From: Wilson , Claire (PLANNING ECOLOGIST) <ClaireWilson3@barnsley.gov.uk>
Sent: 20 March 2024 17:10
To: Bennett , Laura (SPATIAL PLANNING PROJECT MANAGER)
Cc: DevelopmentControl & DevelopmentManagement
Subject: 2024/0122

Thankyou for consulting me on the above application. Please find my comments in relation to biodiversity below.

Figure 8. Post-development Habitats Plan

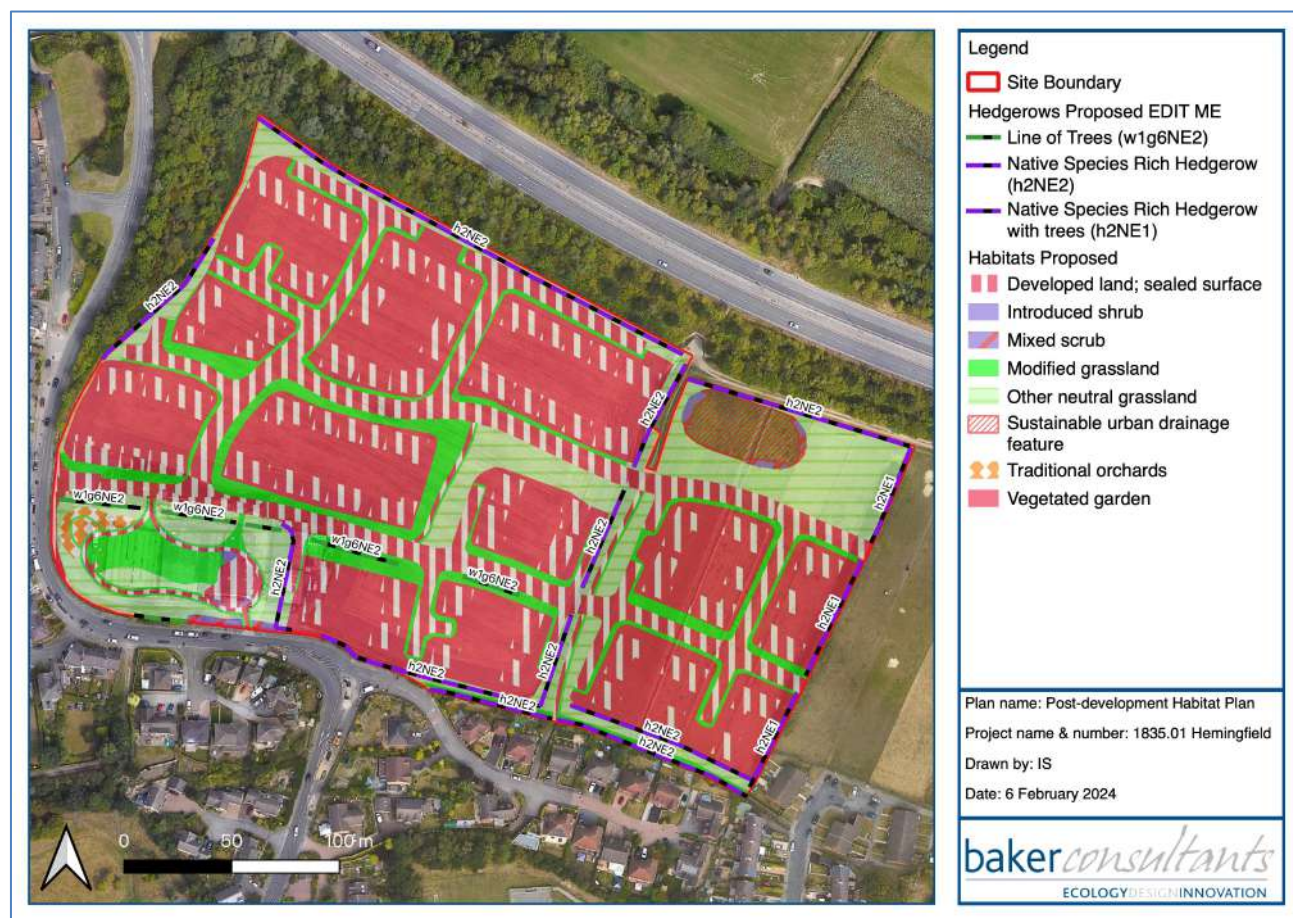
- As this is an outline application the landscaping plans are subject to change at the reserved matters stage. As such, any changes to the landscaping should be included within an updated version of the metric to ensure no net loss of biodiversity. As the application was submitted prior to the 12th February 10% BNG is not applicable to the development. This can be secured via planning condition.

- I am content with the proposed habitats within the landscape masterplan and feel that they are appropriate and achievable. My only comment would be that the traditional orchard should be located in the north western corner of the site away from Hemmingfield road and closer to the woodland on the sites northern boundary.
